CONSTRUCTION DRAWINGS FOR REX ROAD AT FALCON REGIONAL PARK IMPROVEMENT PLANS

REX ROAD
 AT FALCON REGIONAL PARK
 STREET AND UTILITY PLANS
 COVER SHEET

REX ROAD
 AT FALCON REGIONAL PARK
 STREET AND UTILITY PLANS
 INDEX AND DETAILS SHEET

SCALE : N.T.S.

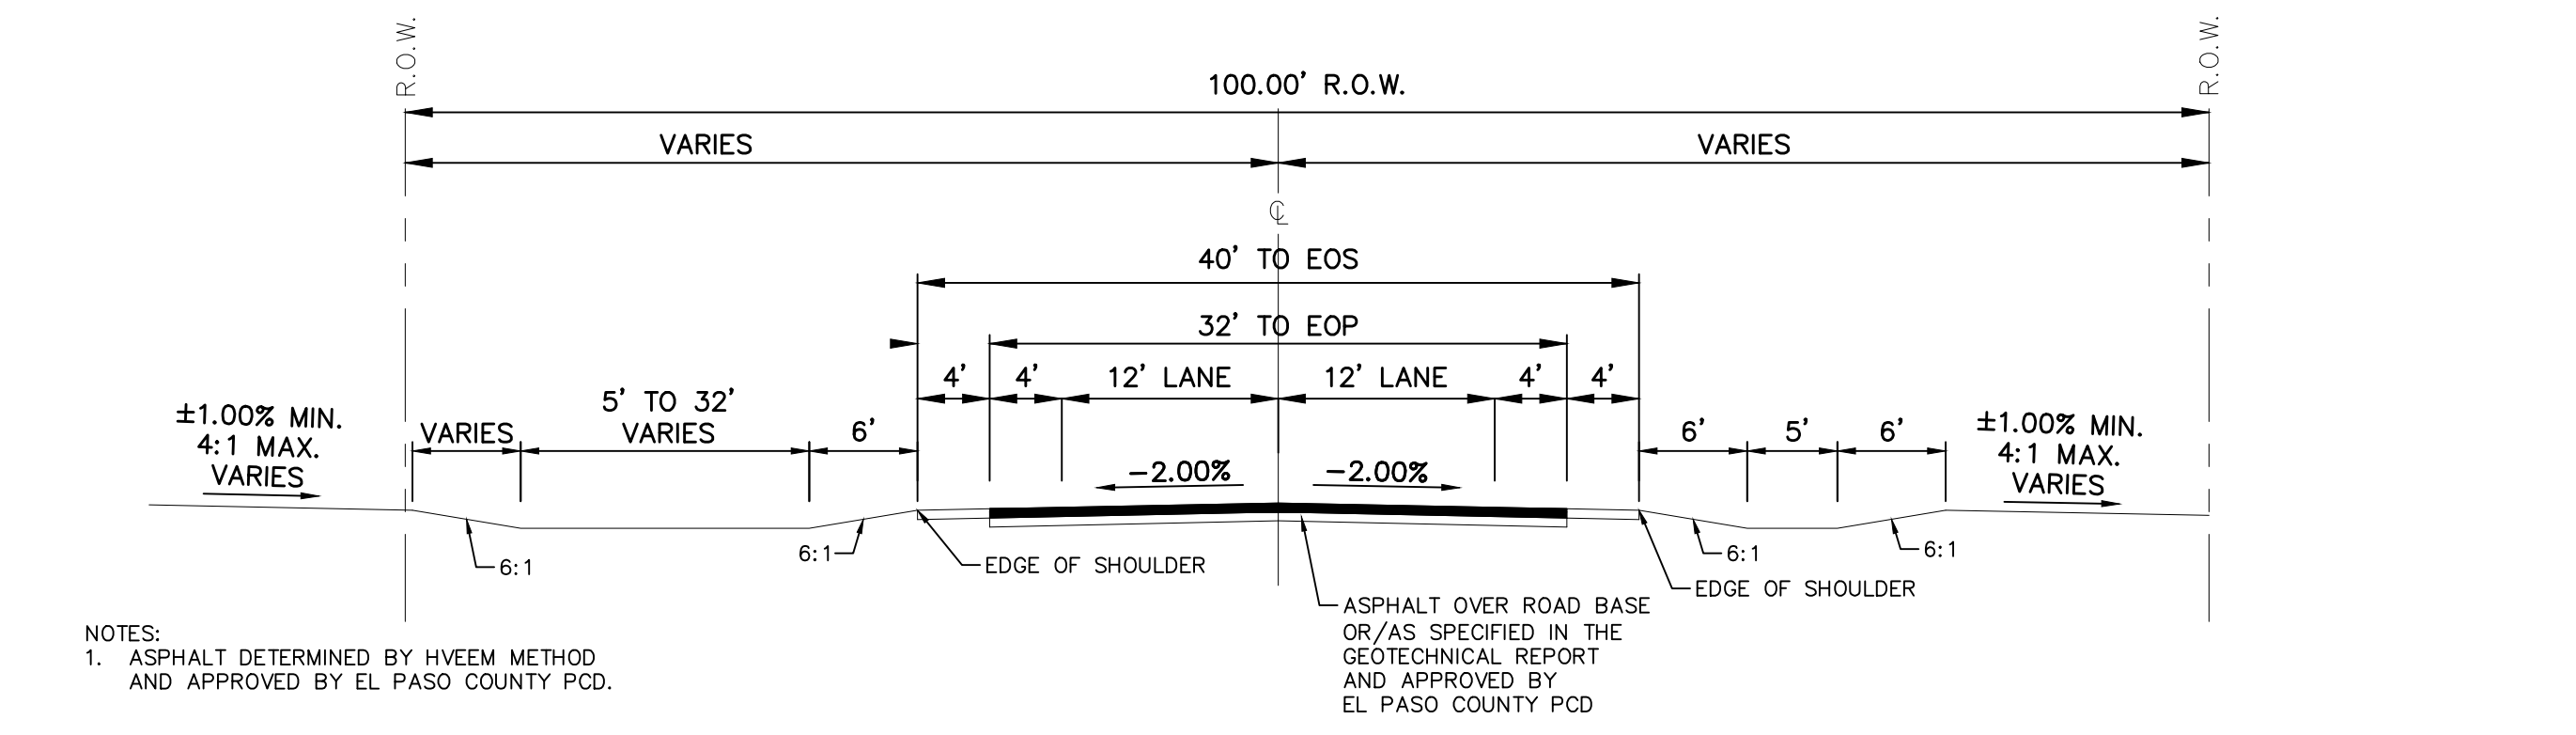
Did you mean cement treated base or are you proposing recycled concrete within the base course?
